ENTECH
ENGINEERING, INC.

**SOIL, GEOLOGY, AND GEOLOGIC HAZARD STUDY
WINSOME SUBDIVISION – FILING NO. 2
A PORTION OF PARCEL NO. 51000-00-493
17480 MERIDIAN ROAD NORTH
EL PASO COUNTY, COLORADO**

January 26, 2021

WINSOME FILING NO. 2
FINAL PLAT
 A PORTION OF SECTION 24, TOWNSHIP 11 SOUTH, RANGE 65 WEST,
 AND A PORTION OF THE WEST HALF OF SECTION 19, TOWNSHIP 11 SOUTH, RANGE 64 WEST
 OF THE SIXTH PRINCIPAL MERIDIAN, COUNTY OF EL PASO, STATE OF COLORADO

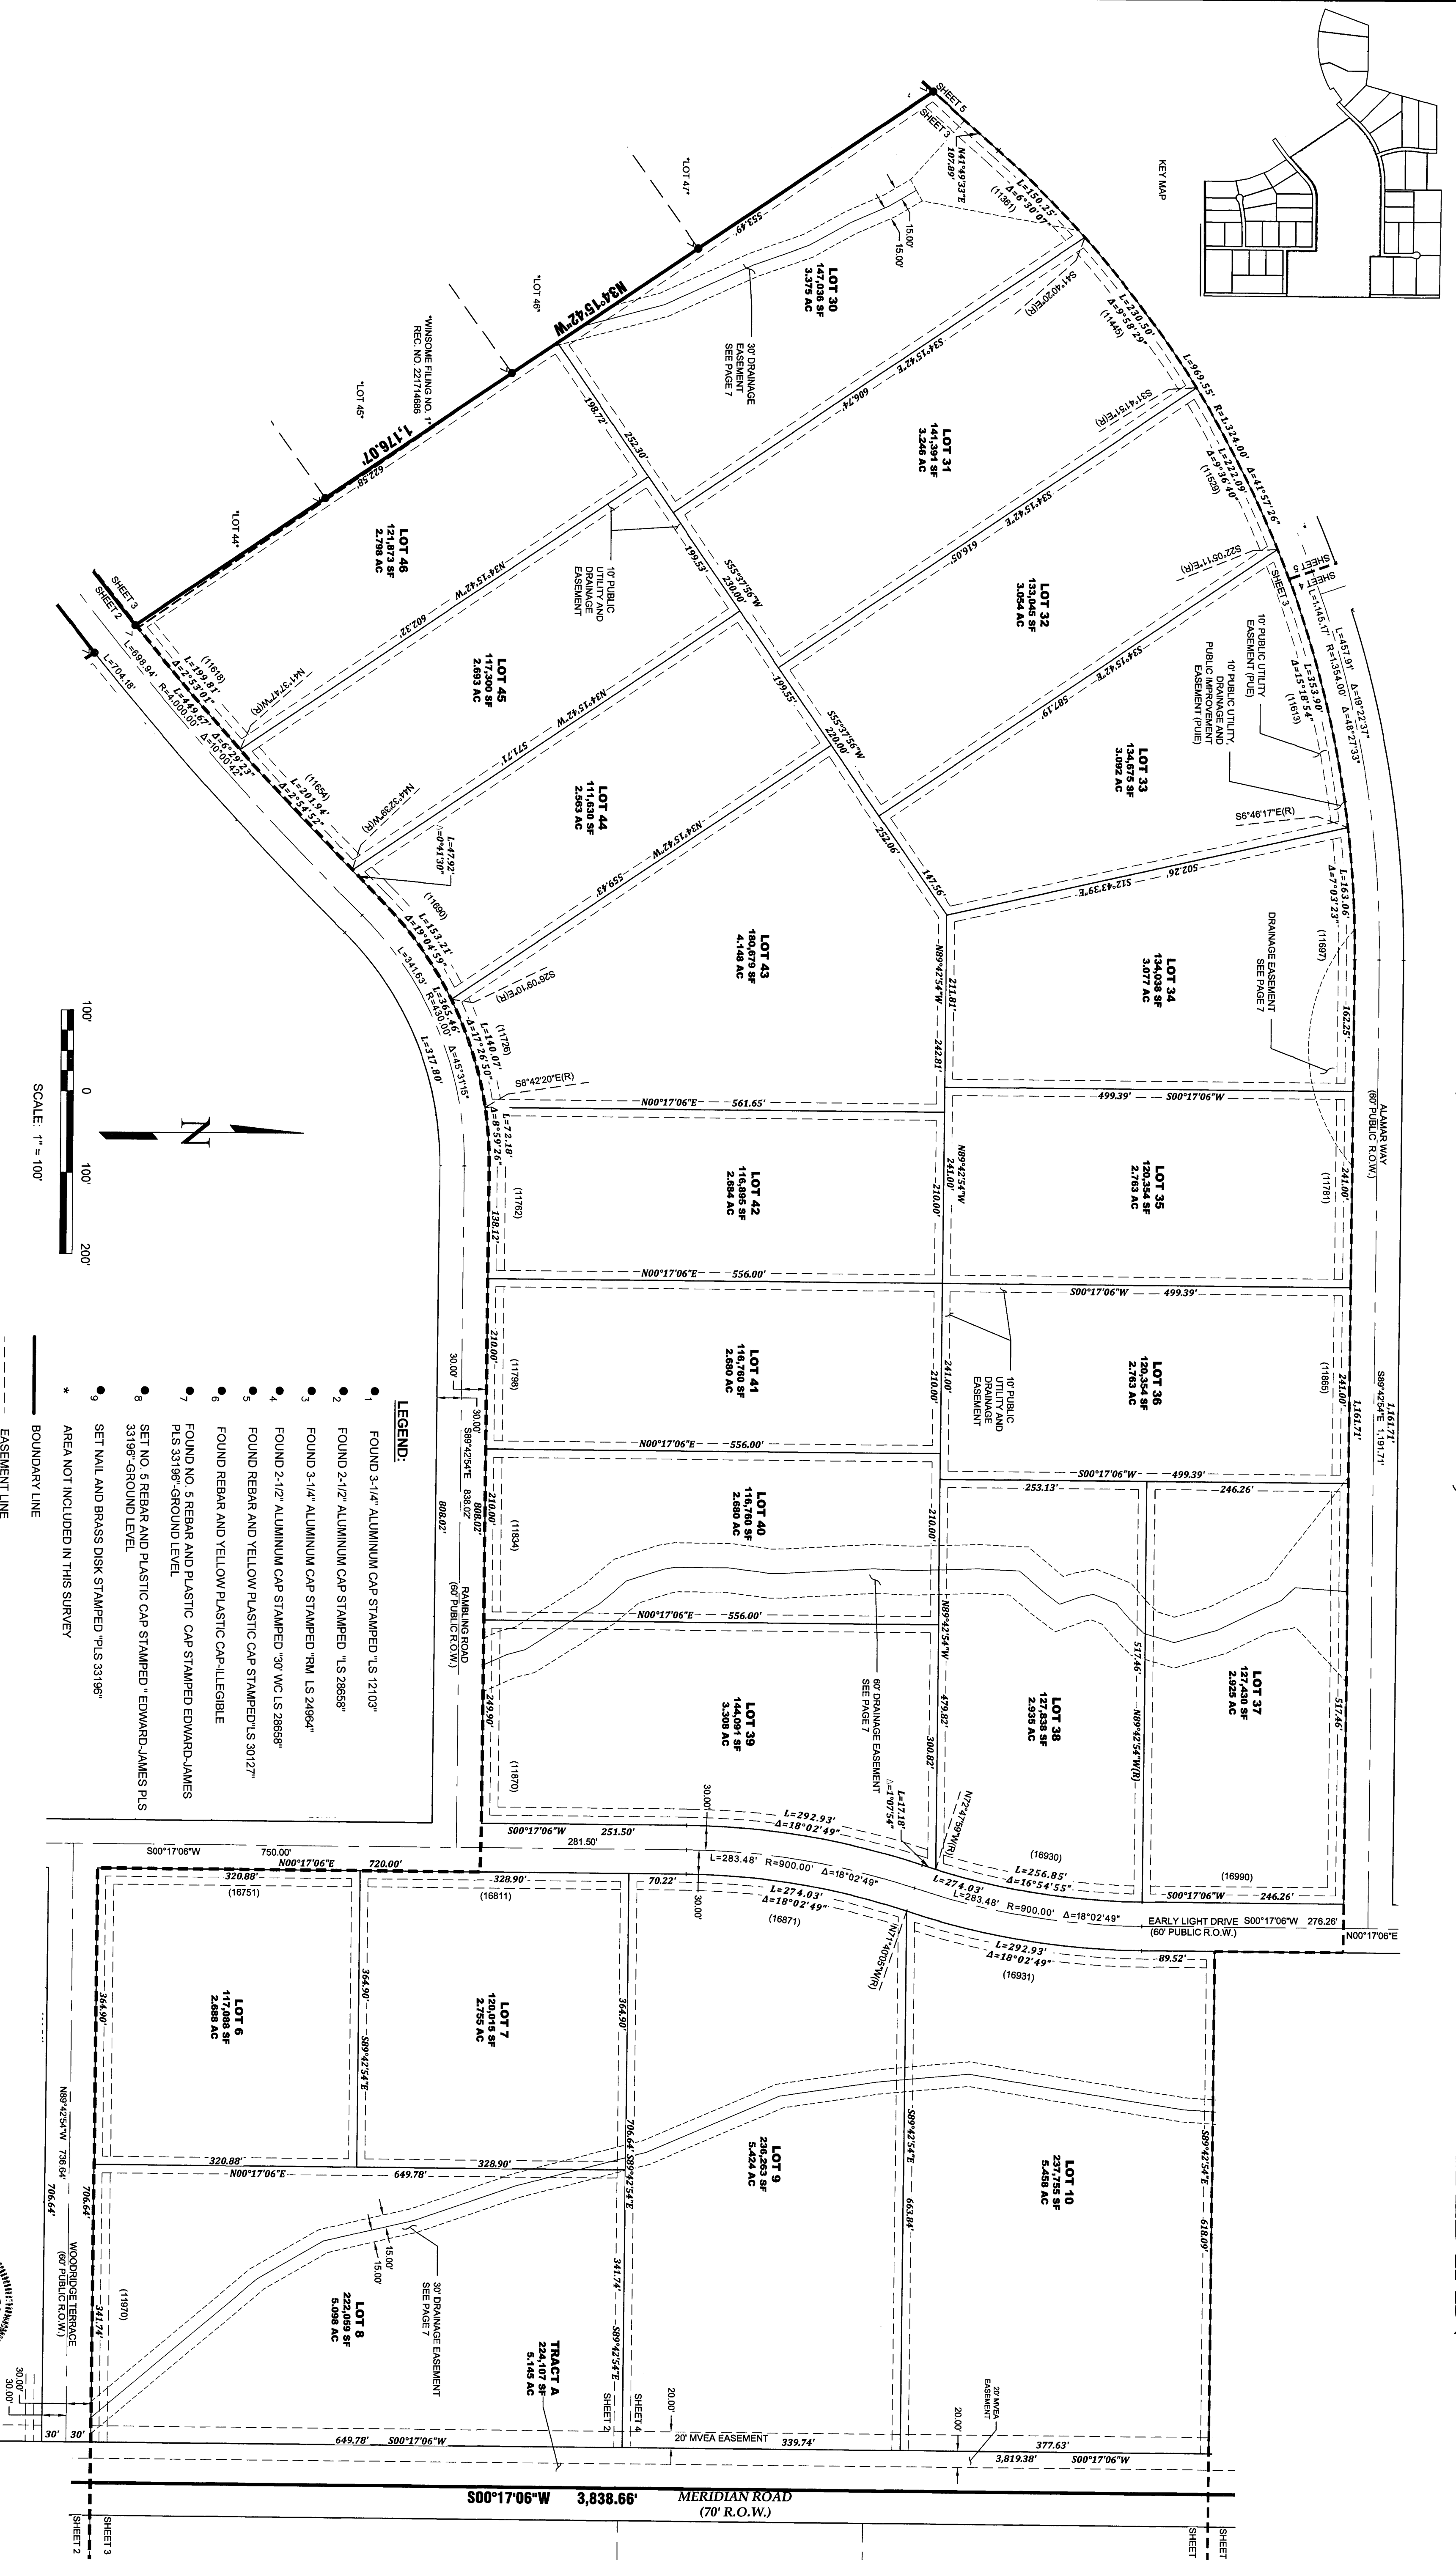
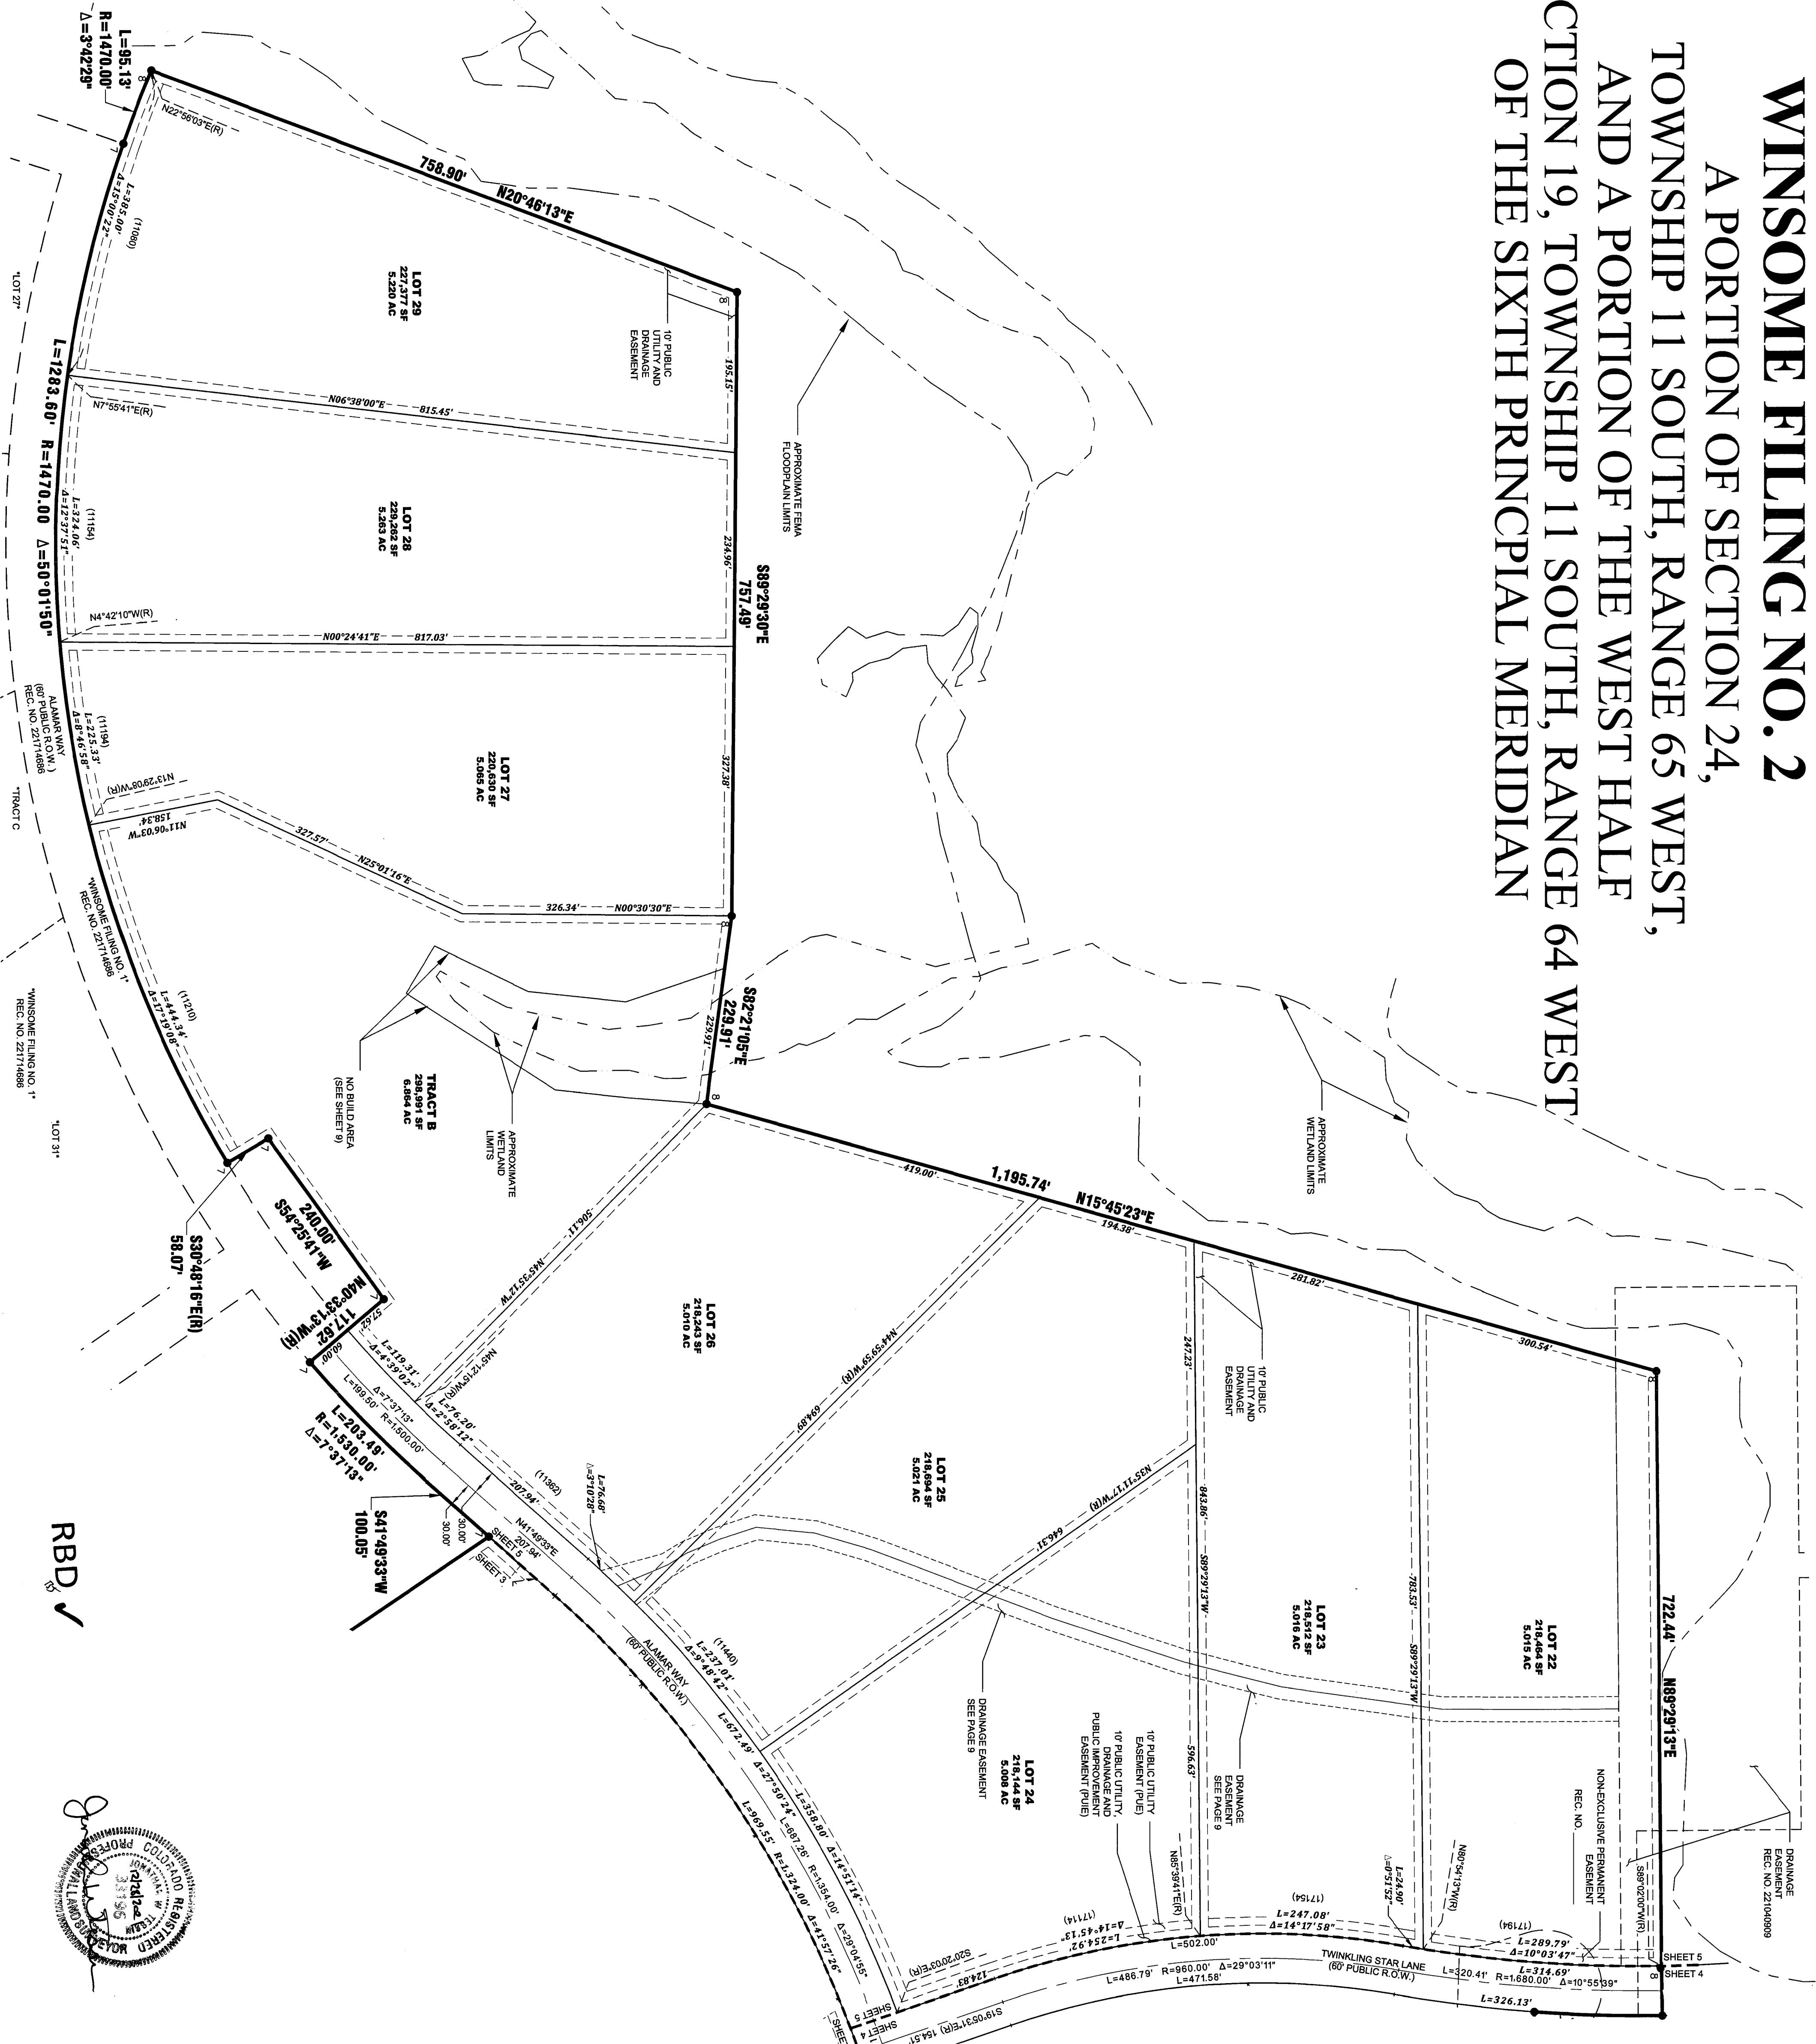
Add as plat note

Show all areas as of seasonal groundwater as
no-build on plat.
